From: Martyn White <Martyn.White@arun.gov.uk>
Sent: 27 January 2022 13:53
To: Maria Tomalova <Maria.Tomalova@arun.gov.uk>
Subject: P/163/21/L

P/163/21/L

Pennicotts Farm Pagham Road Pagham PO20 1LN

Listed Building consent for the demolition of existing conservatory to southern side of building & general repair & maintenance of external brickwork & roof coverings, insertion of 2 No

Ve.	In.	Project	Title	House A
A	FR	Pennicotts Farm	FF Staircase	
B	FR	PO20 1LN		
C	FR

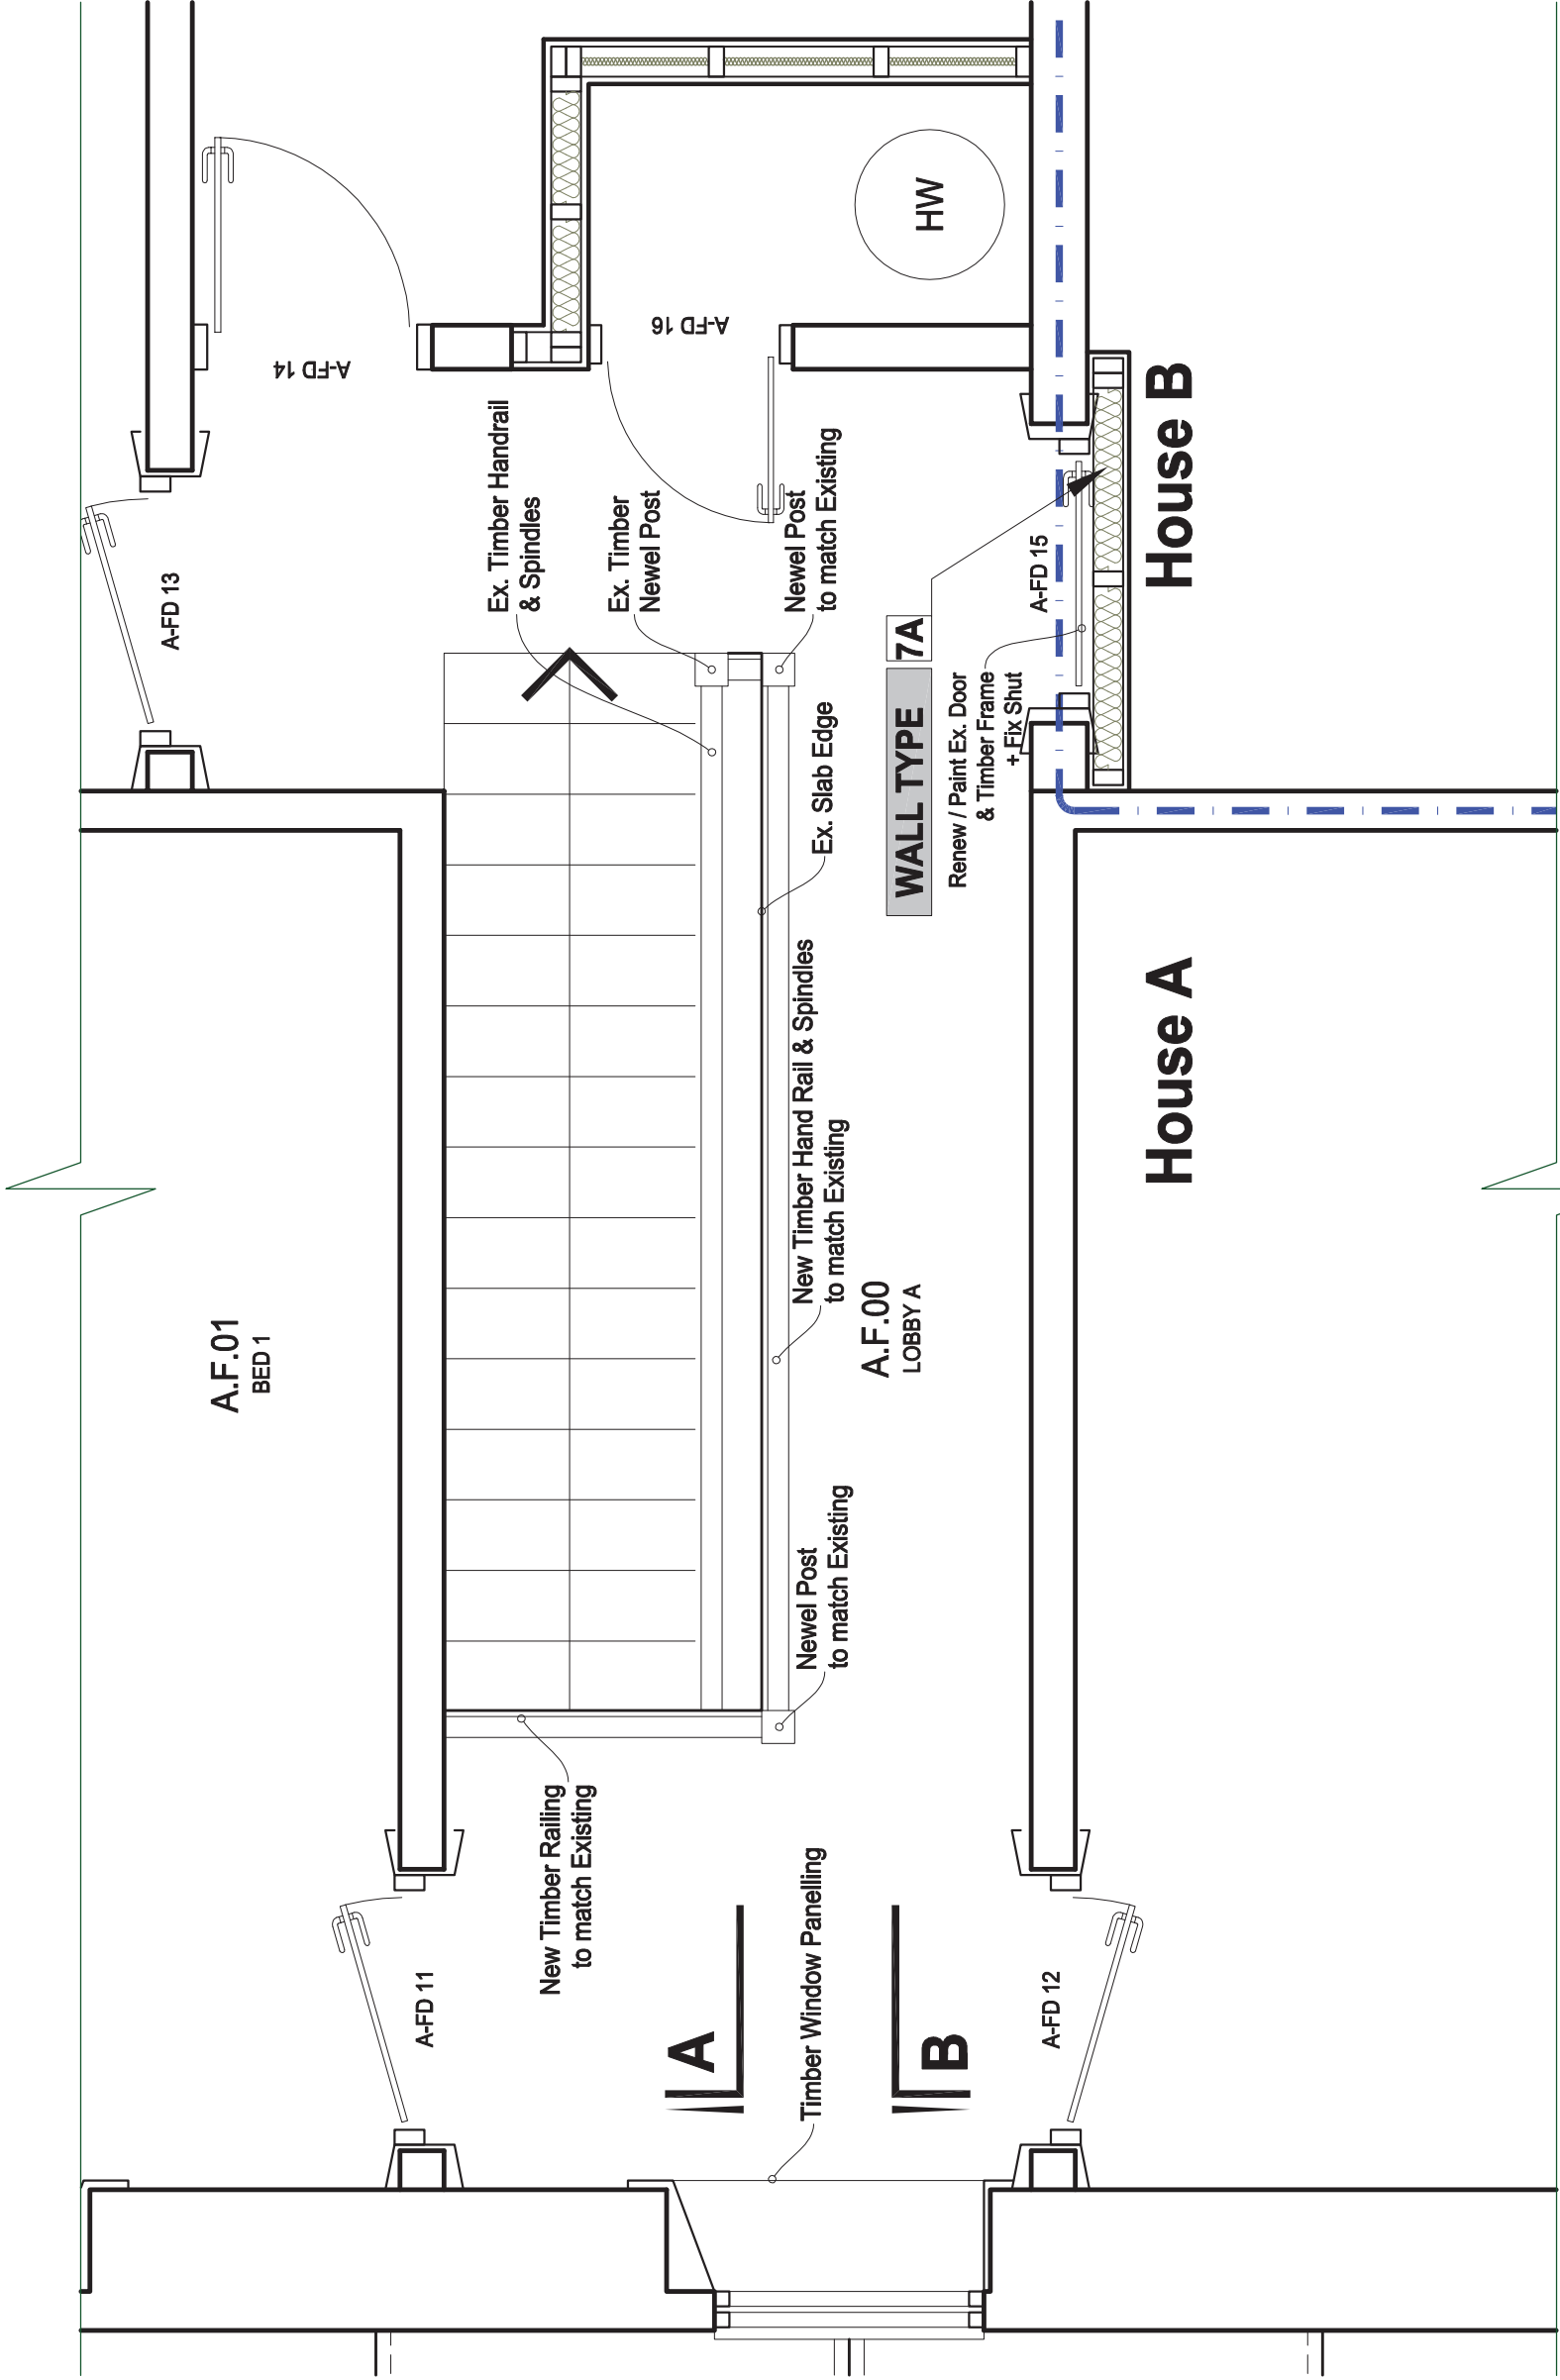
On the floor plan (FF Plan Structure) and 'House B FF Staircase' it looks as though door A-FD15 is removed (reference is made to 'block up opening.....'), whereas in both the plans showing the 'section for house A staircase' (House A section staircase B-B section) and 'House A FF Staircase', the door is to be fixed shut – which is correct? The latter is the acceptable approach, whereas the former is not. There is also another door which will be blocked up and the door recycled, without justification in the first floor of landing B. It is also not clear from the various plans what would happen to the 're-cycled' doors
